Please ask for: Ms Iqraa Malik
Email: iqraa.malik@terraquest.co.uk
Telephone: 0121 234 1390
Our Ref: AL/20/25/A
Your Ref:
Date: 5th March 2025

Application for Consent to Display an Advertisement(s)

Development: Installation of various signage.
Location: Shop Around The Clock And Aldingbourne Post Office Westergate Street
Westergate PO20 3QL

Item 3  
Two Digitally printed vinyl graphics  
applied to glazing.  
Size: As shown  
Scale: 1:10

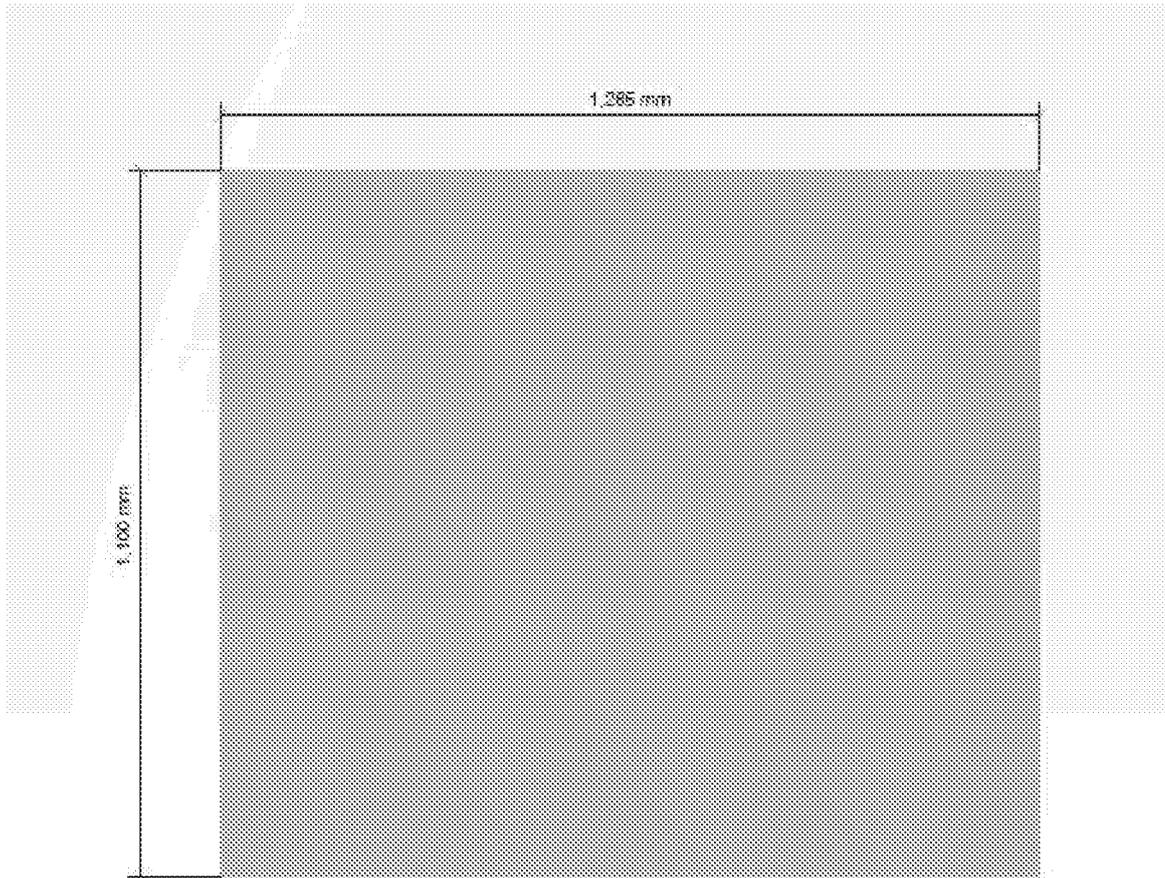
The scale listed for item 3 is 1:50, however it appears to measure to a scale of 1:10, please review and amend. In addition to this, the height and width for this sign have been mixed up on the application form, please amend.
